From: Stephanie Evans [REDACTED]
Sent: 18 February 2021 14:10
To: Planning.Responses <Planning.Responses@arun.gov.uk>
Subject: RE: Planning Consultation on: BN/17/21/PL

Application No: BN/17/21/PL
Registered: 8th February 2021
Site Address: The Cottage Highground Lane Barnham PO22 0BT
Grid Reference: 495405 103850
Description of Works: 1 No; new dwelling. This application is a Departure from the Development Plan & is in CIL Zone 3 & is CIL Liable as new dwelling.

DRAWING TITLE:
PROPOSED DWELLING ADJACENT TO
EXISTING DWELLING
Proposed Landscaping &
Biodiversity Plan

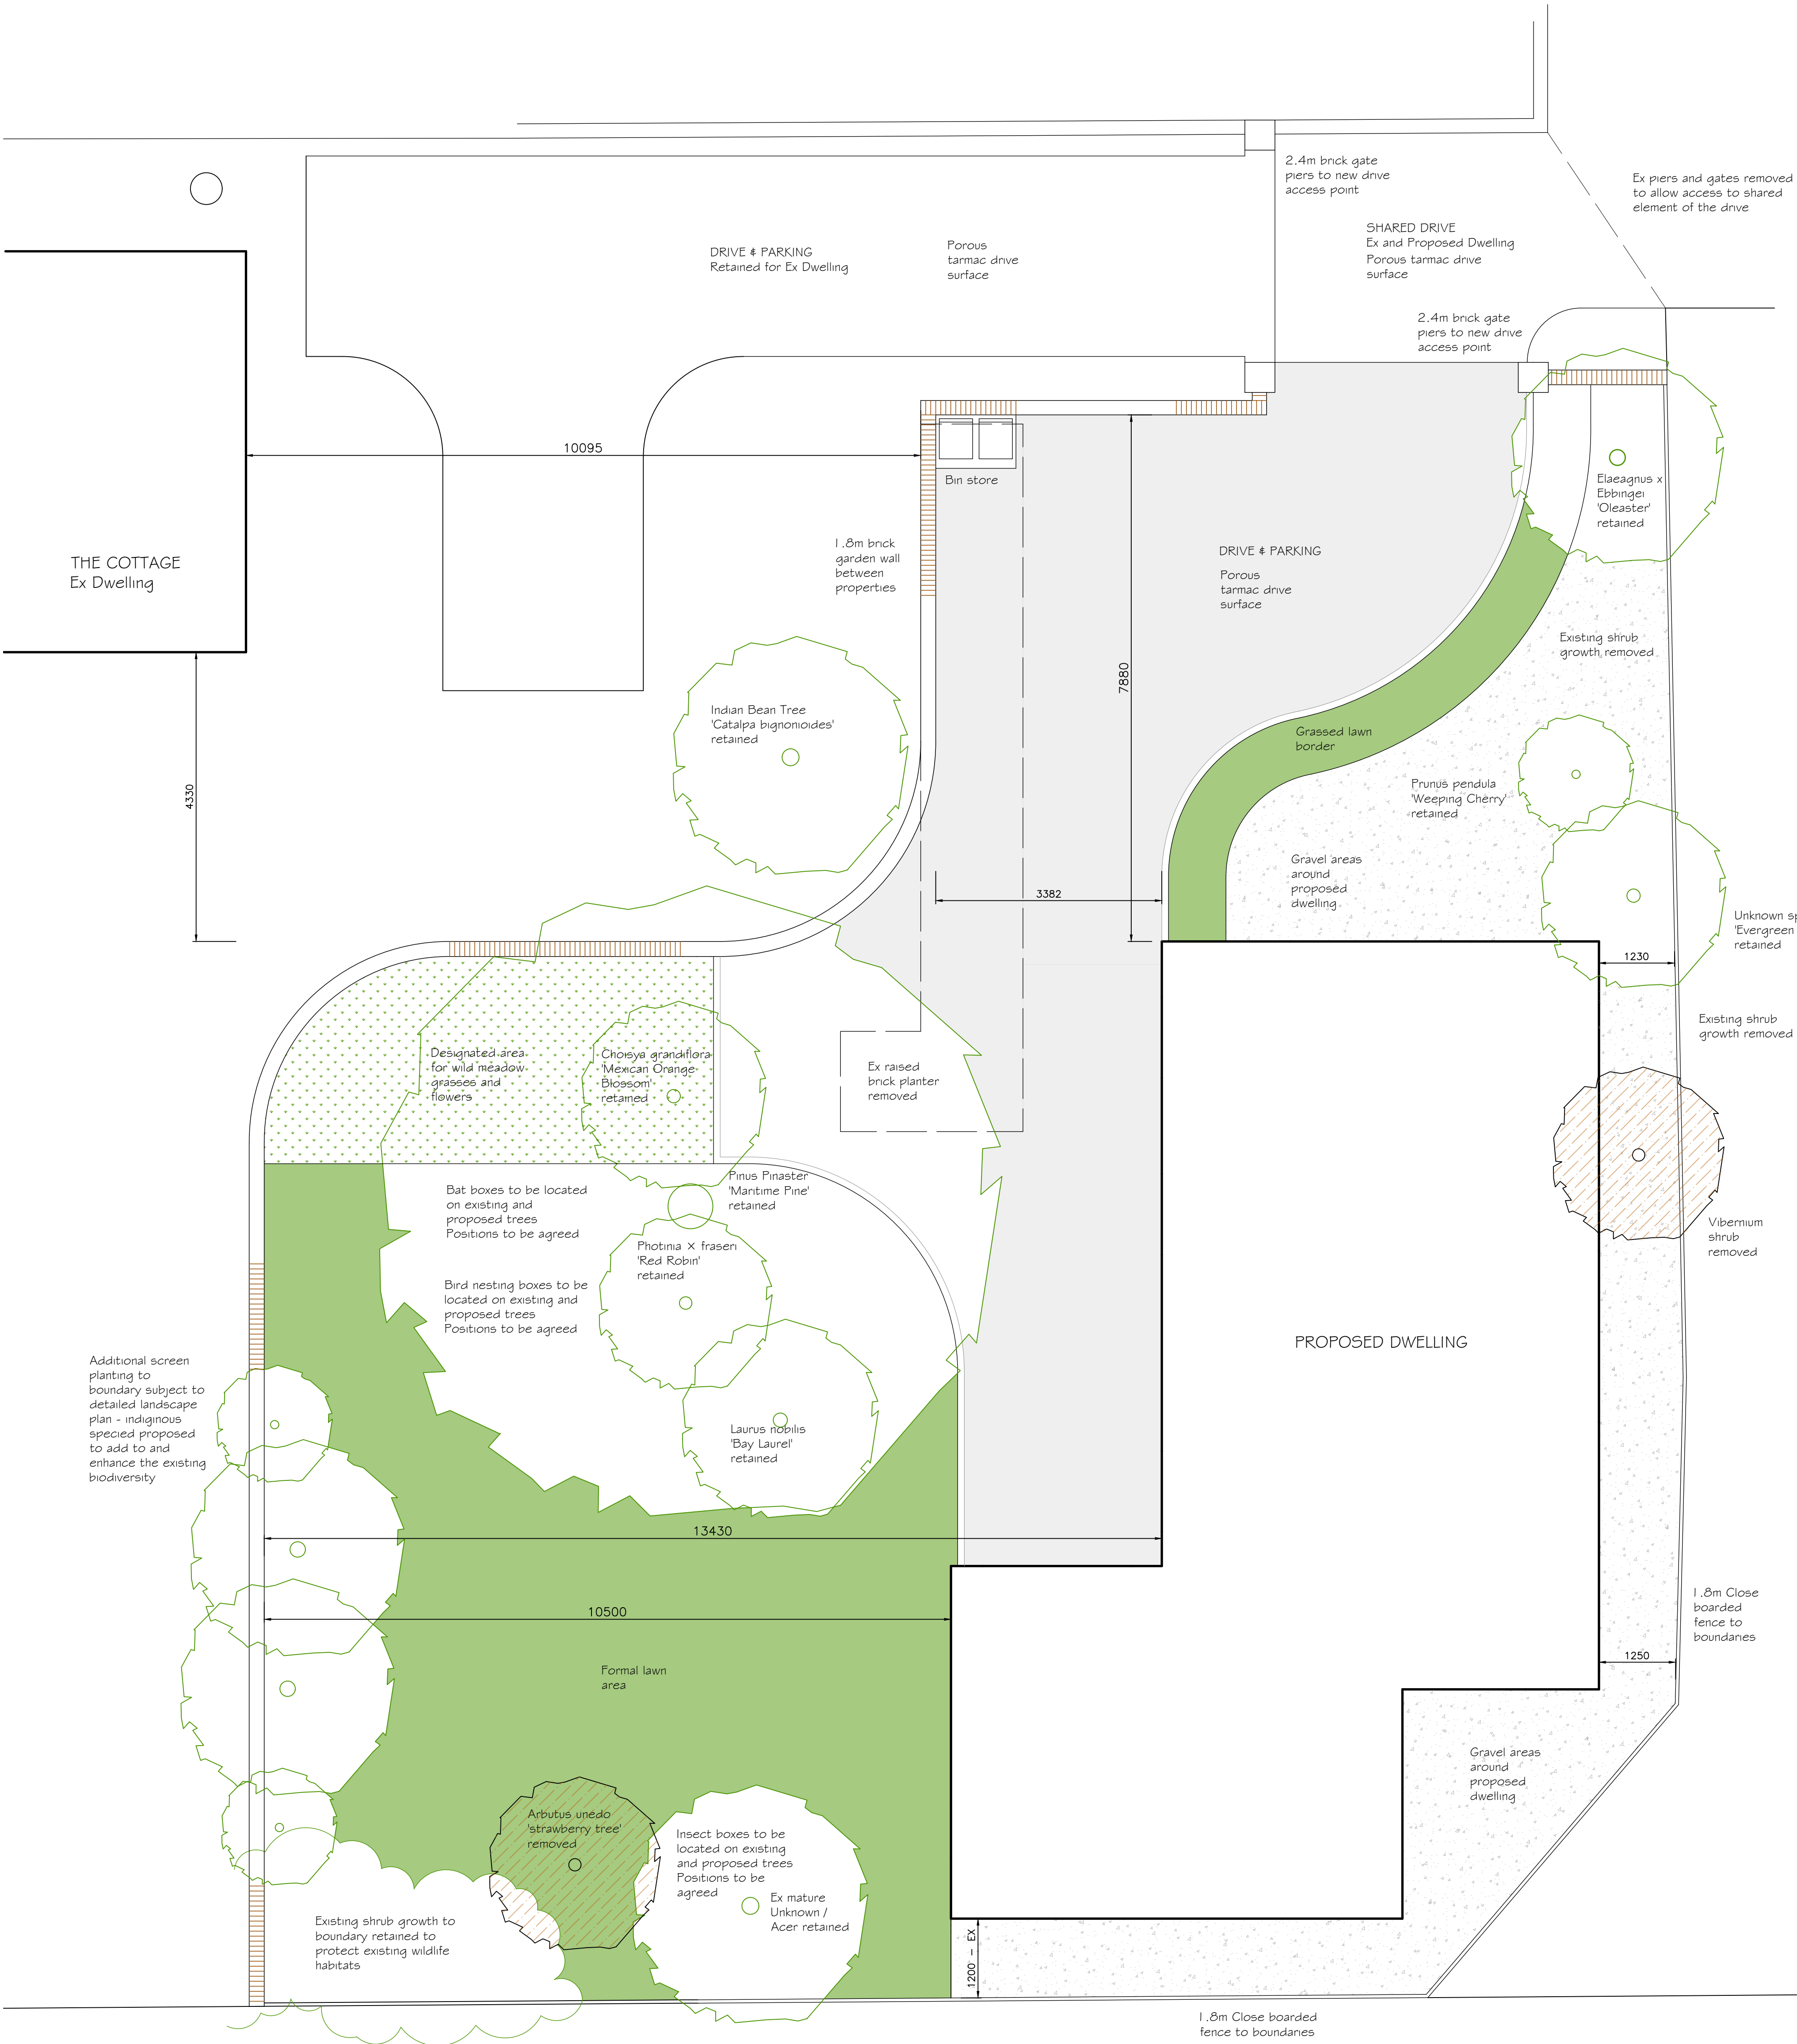
We require that a bat box is installed on the buildings onsite facing south/south westerly positioned 3-5m above ground.

The piles must undergo soft demolition. A hedgehog nesting box should be installed within the site to provide future nesting areas for hedgehogs.

We would like a bird box to be installed on the building and / or tree within the site.
